**M54 to M6 Link Road**

**TR010054**

**8.8 O(D) Statement of Common Ground  
with Staffordshire Wildlife Trust**

<b>Version</b>	<b>Date</b>	<b>Status of Version</b>
6 (P08)	26 March 2021	Issue to the ExA for Deadline 7

Drawing Title
FIGURE 8.3:
PHASE I BASELINE HABITAT
SURVEY RESULTS

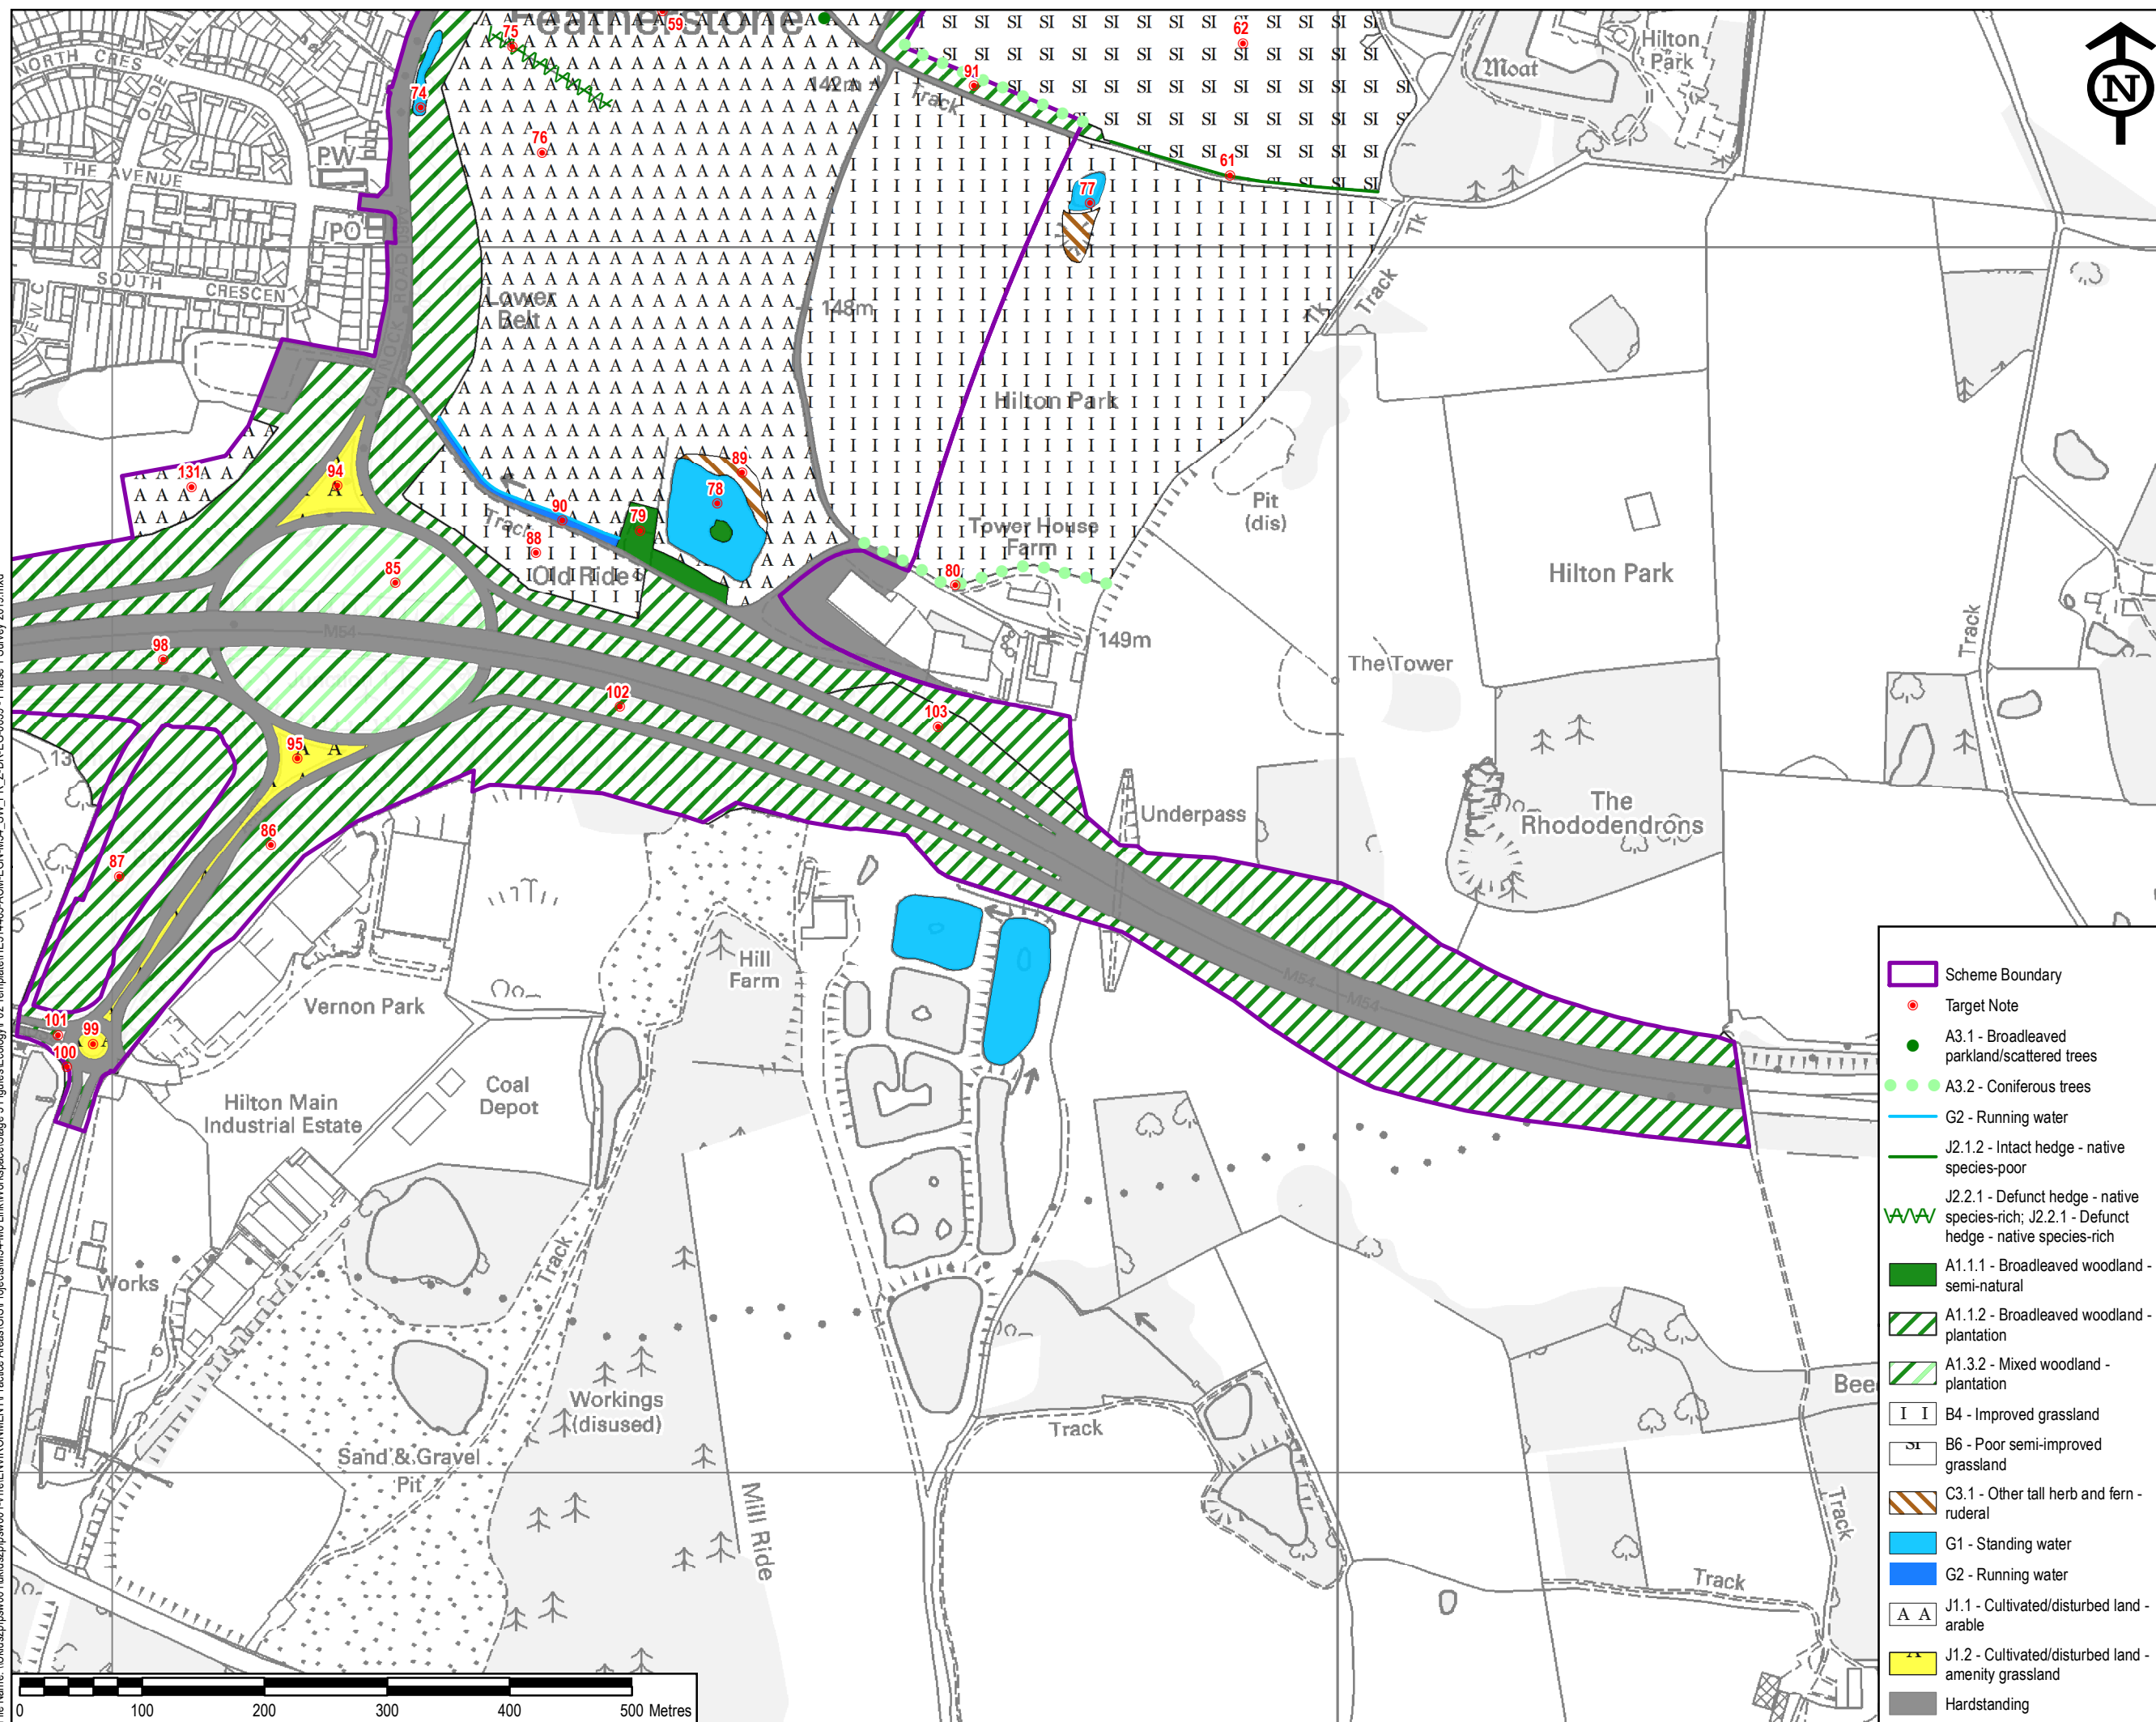
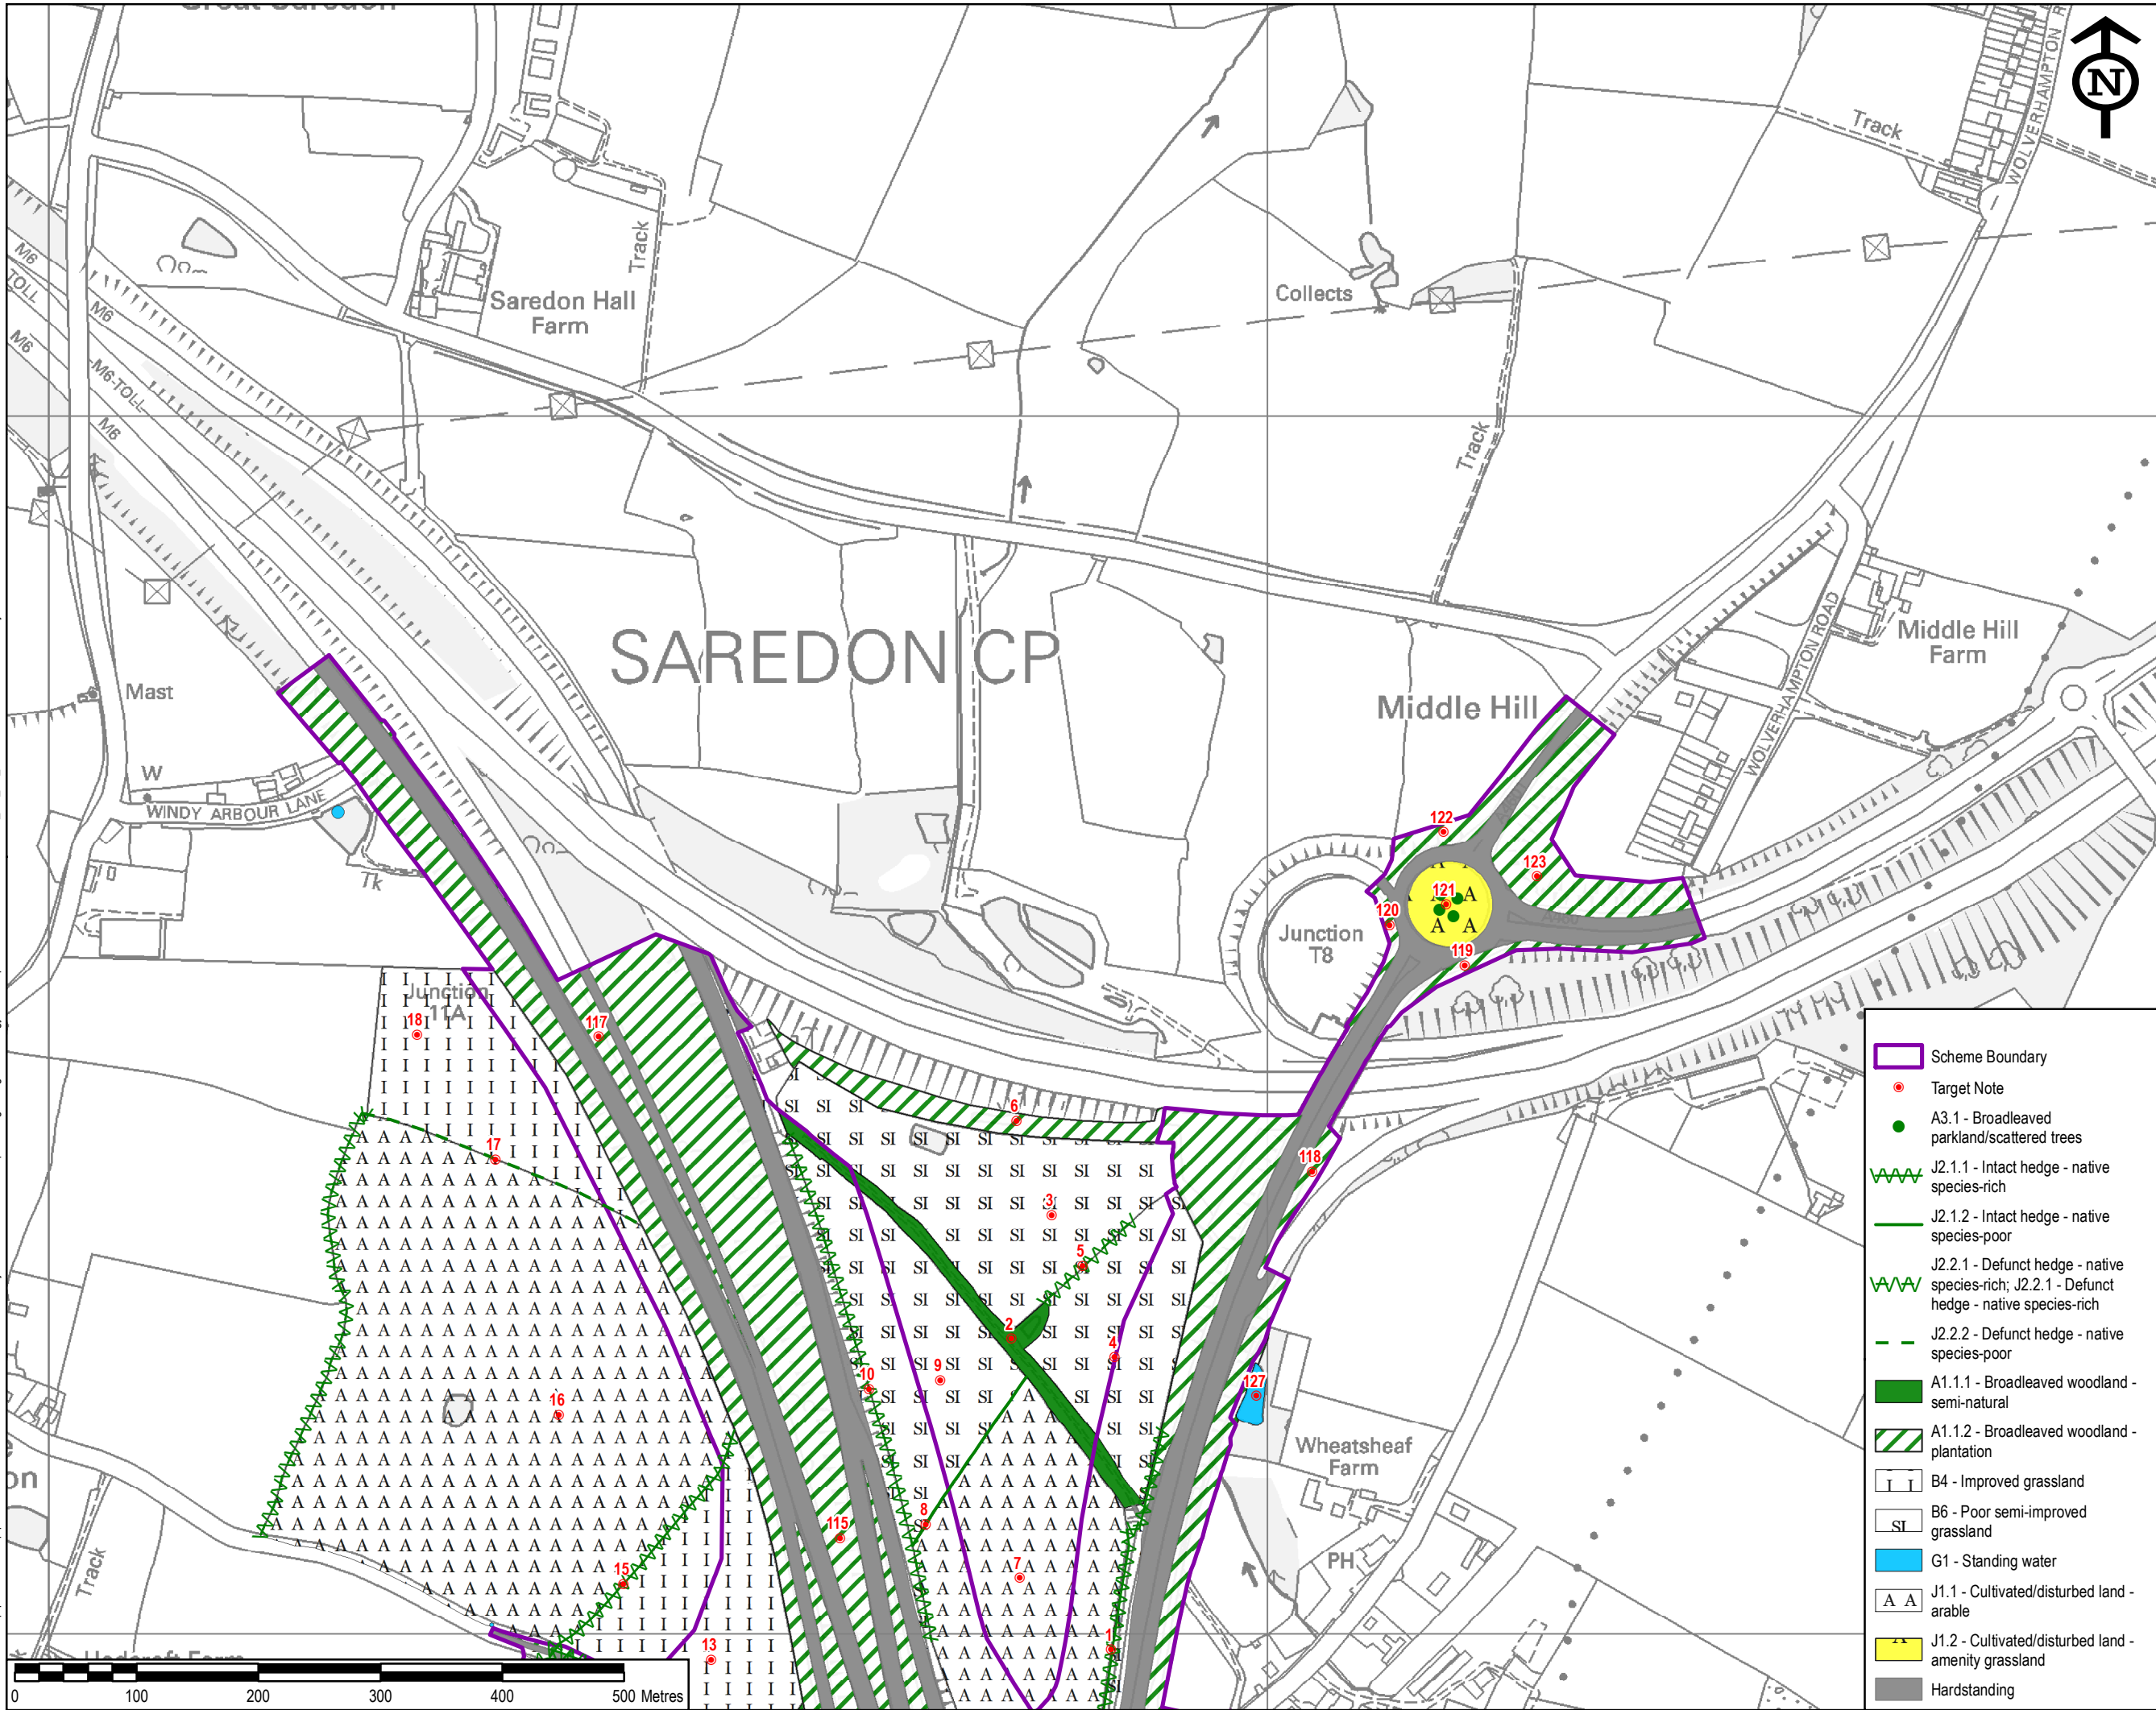
Baseline data <b>RR-042m</b>	Figure 8.3 Phase I Baseline Habitat Survey [APP-113/6.2]	<p>Figure 8.3 Phase I Baseline Habitat Survey does not show habitat survey data for the area.</p> <p>Following discussions at the meeting held on the 11 November, SWT agree with the approach adopted by</p>	<p>Figure 8.3 of the ES [APP-113/6.2] shows the results of the phase 1 habitat survey undertaken in 2018 and 2019. The area surveyed included all land within the Scheme boundary and up to 50m beyond the Scheme boundary where access permitted. This is considered an appropriate distance to assess the potential</p>	Agreed	Agreed	Agreed
